DELEGATED ITEM FILE REPORT - APPROVAL

Application No:	3/2012/0254/P (LBC) & 0255 (PA)
Development Proposed:	Conversion of barn into one dwelling at Chadwicks Farm, Settle Road, Bolton-by-Bowland

drawing:
Proposed Plans, Section and Elevations

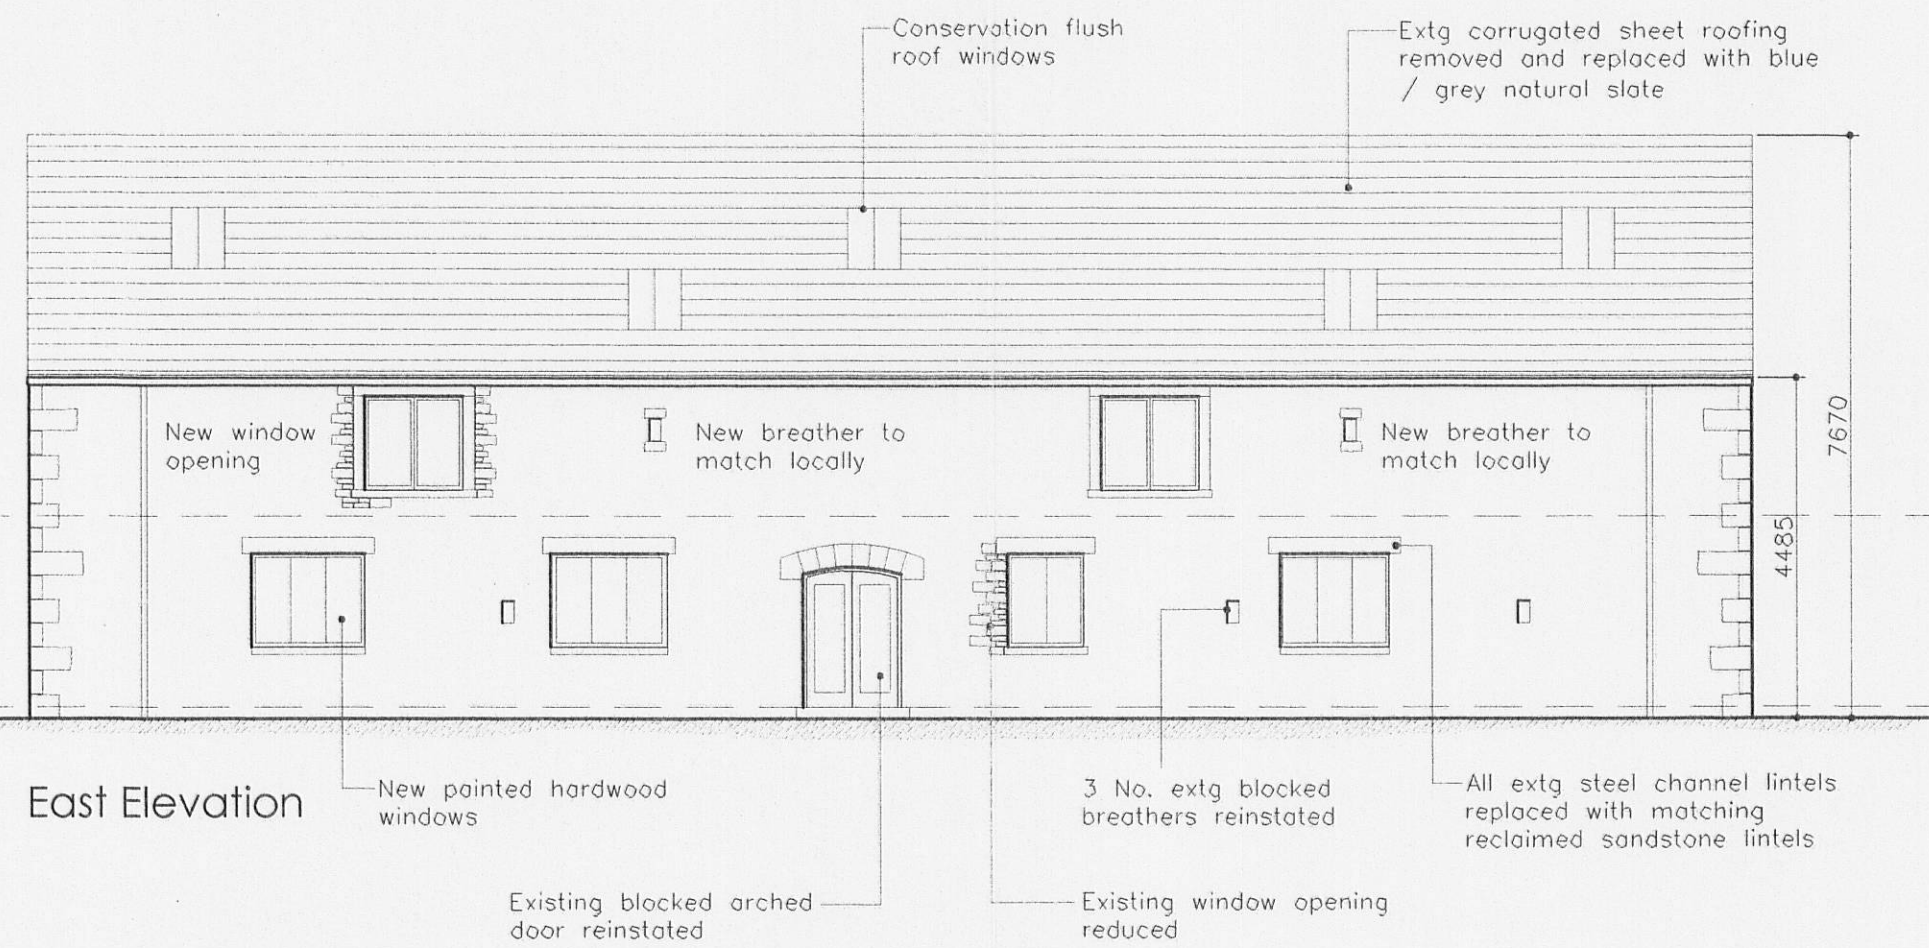
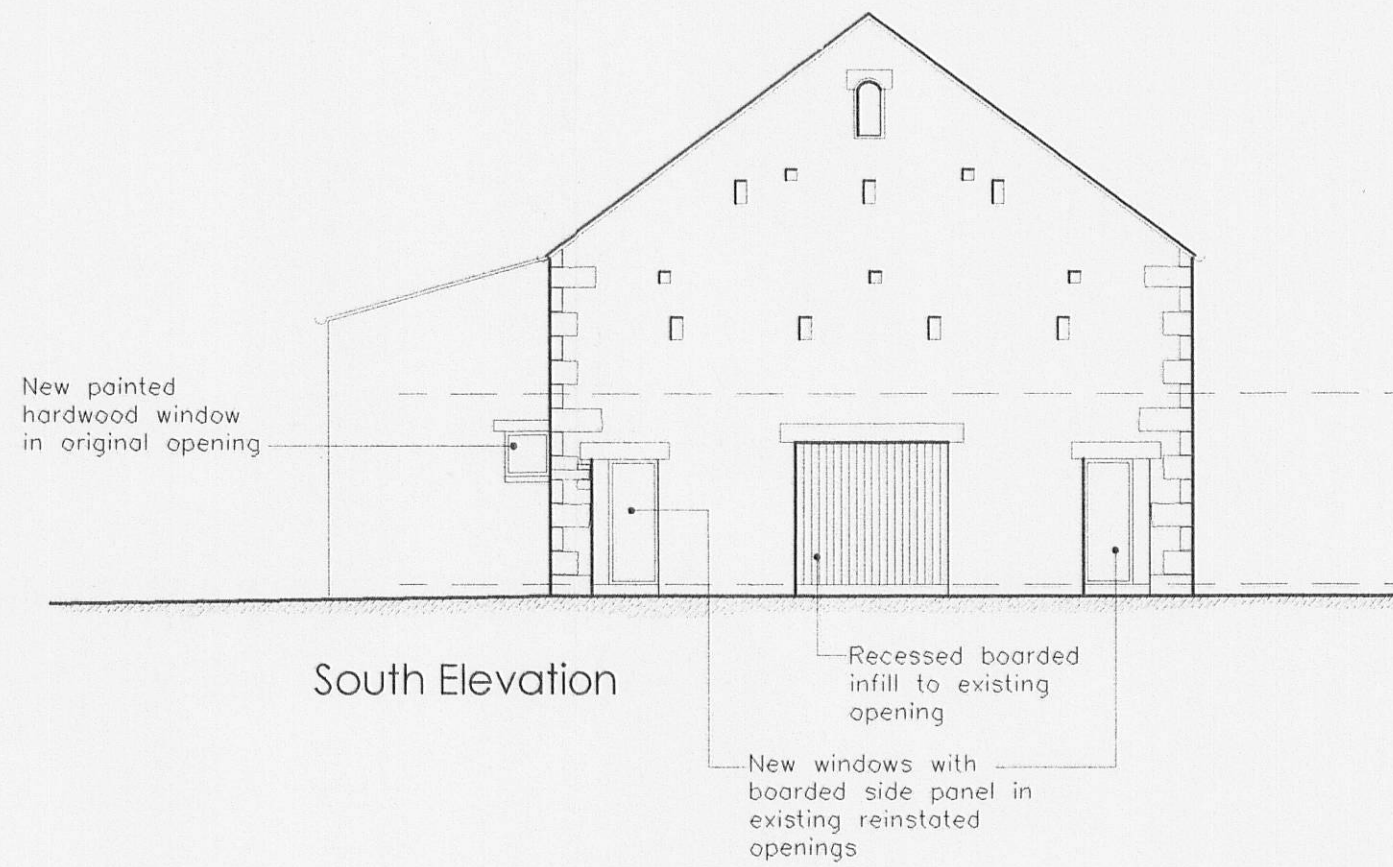
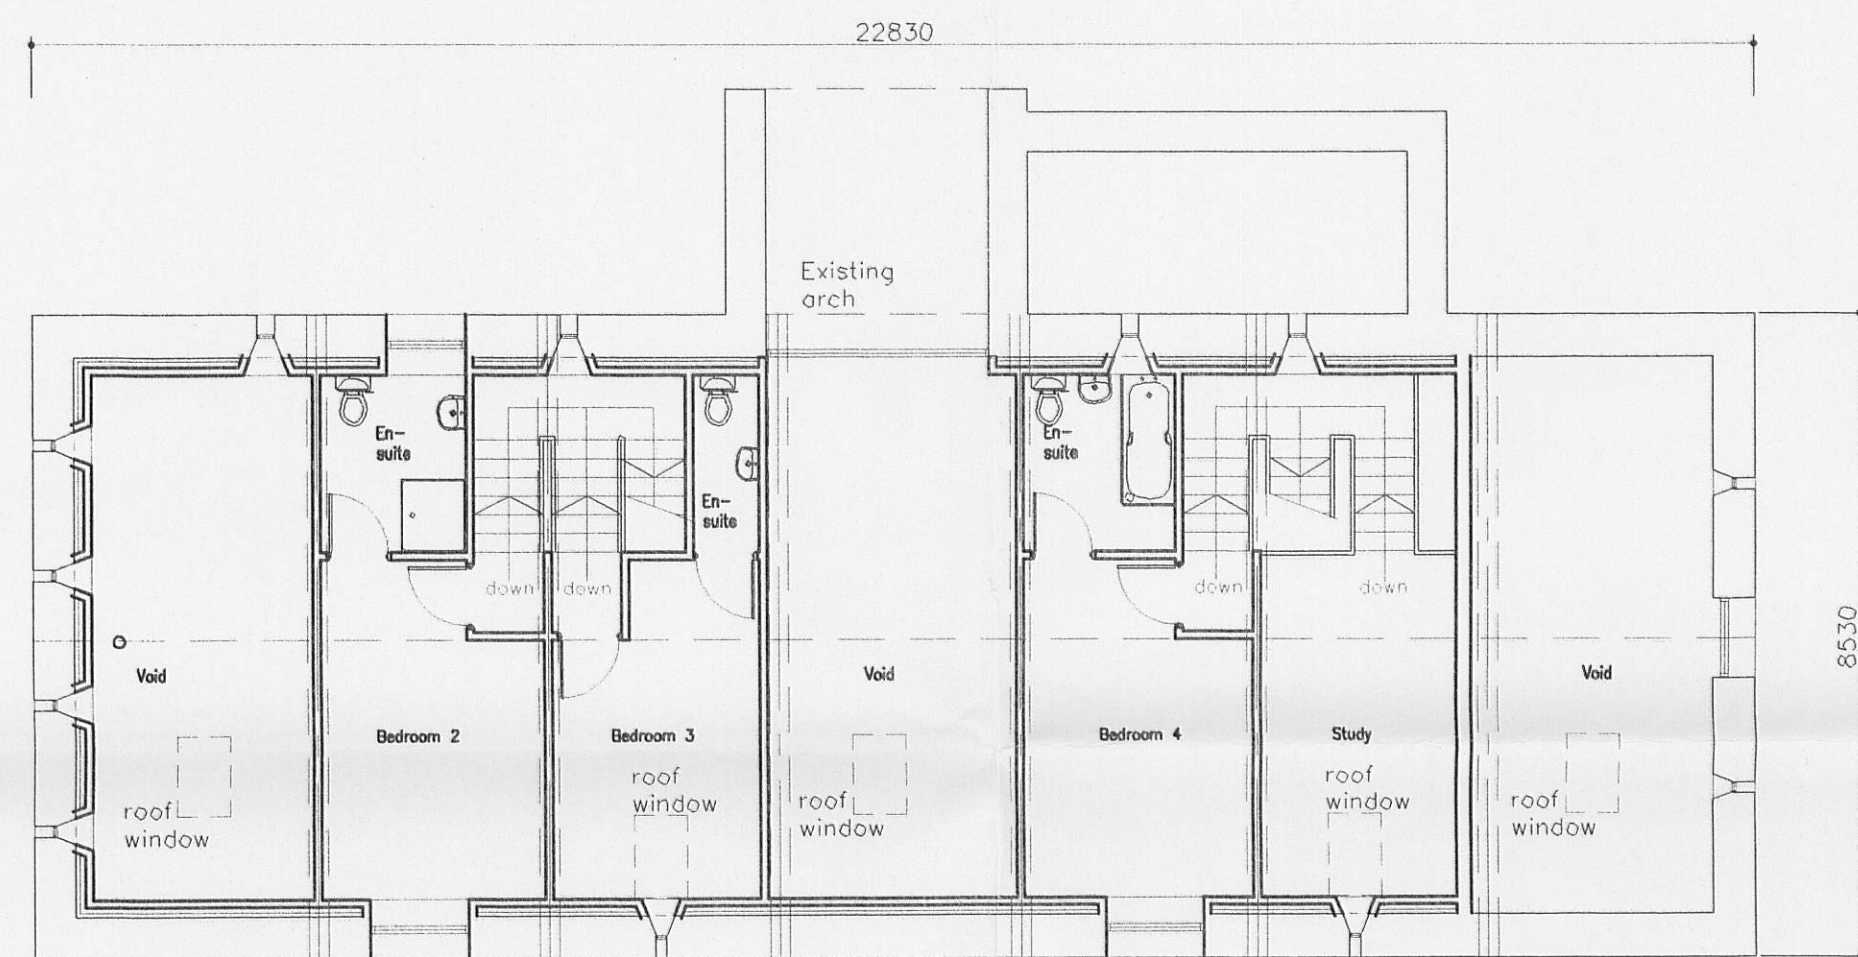
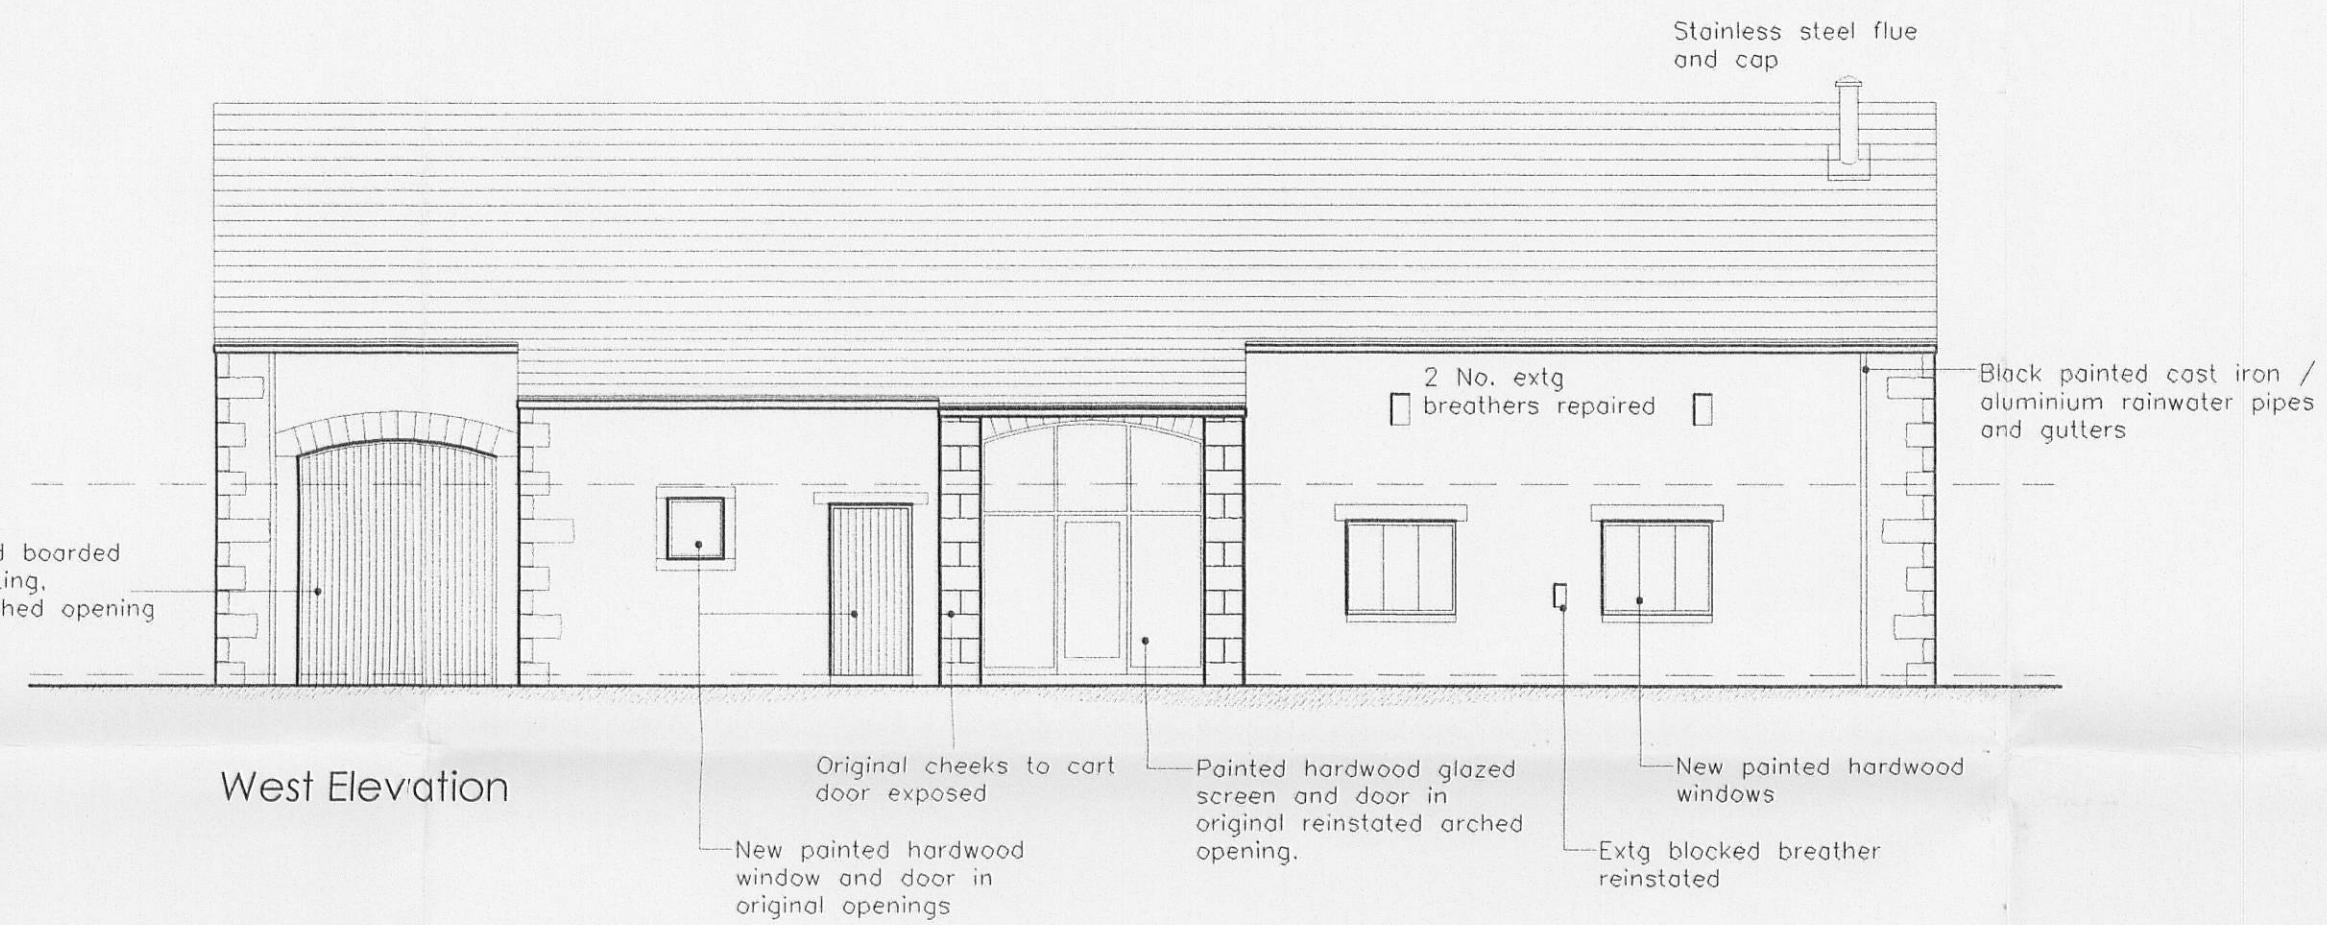
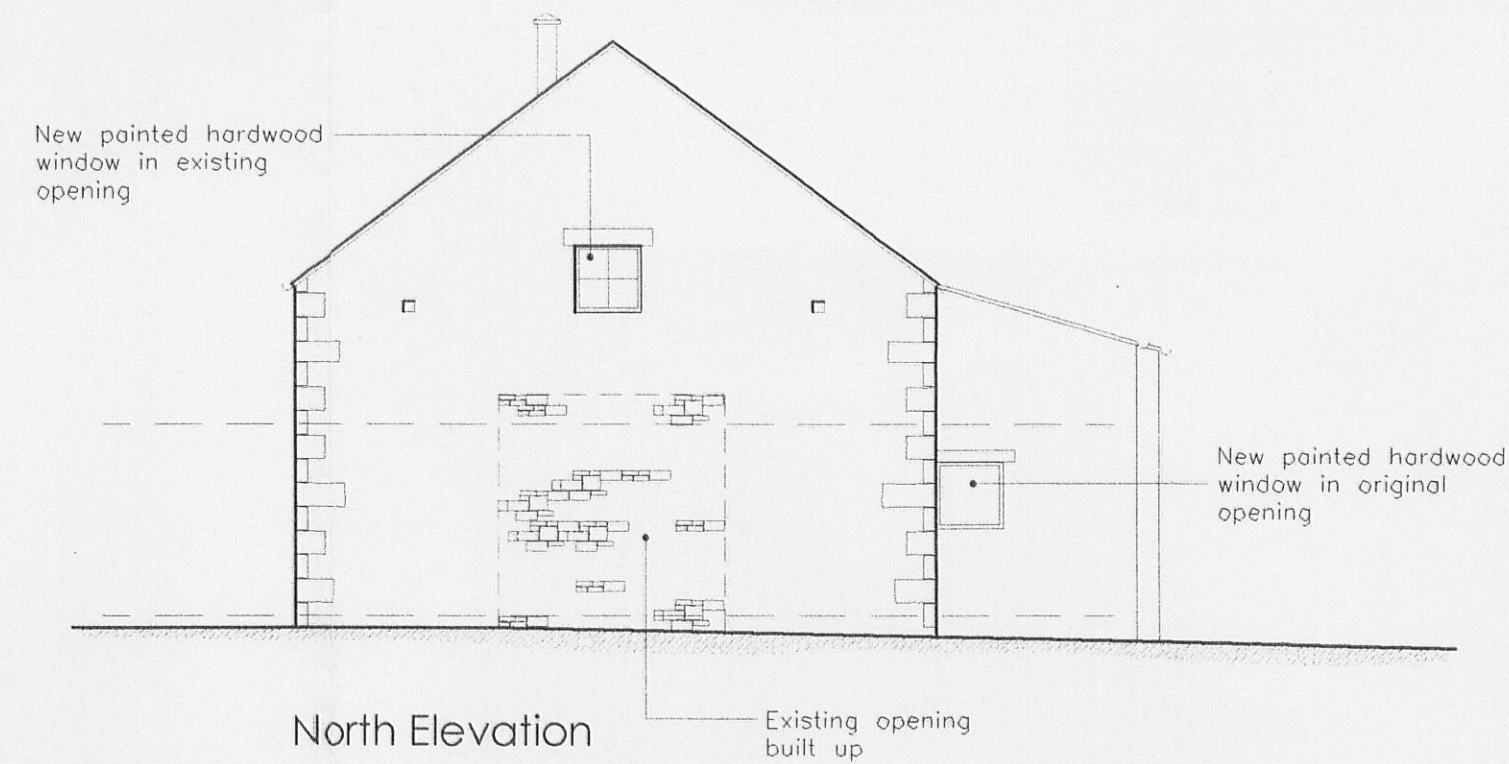
In my opinion, the scheme now proposed is based upon a thorough understanding of the significance of the historic agricultural building and is acceptable. The scheme includes enhancements to the significance including exposure of the original c.1700 cart door and porch and restoration of the full-height threshing bay. Whilst there are also losses to the significance including removal of important evidence for the changing historic usage of the barn e.g. unblocking of the second cart door (possibly original and with two historic layers of change), these adverse impacts can be minimised by the imposition of conditions i.e. deleting unnecessary roof lights from the three full-height bays and reducing the size of the new window to Bedroom 2.

The proposal, subject to amendment by condition, has an acceptable impact upon the character (including setting) and significance of the listed building and heritage asset, the landscape and character of the Forest of Bowland Area of Outstanding Natural Beauty, residential amenity and highway safety. It is acceptable residential development in the open countryside. This is in accordance with Policies ENV20, ENV19, ENV1, G1, H2, H15, H16 and H17 of the Ribble Valley Districtwide Local Plan.
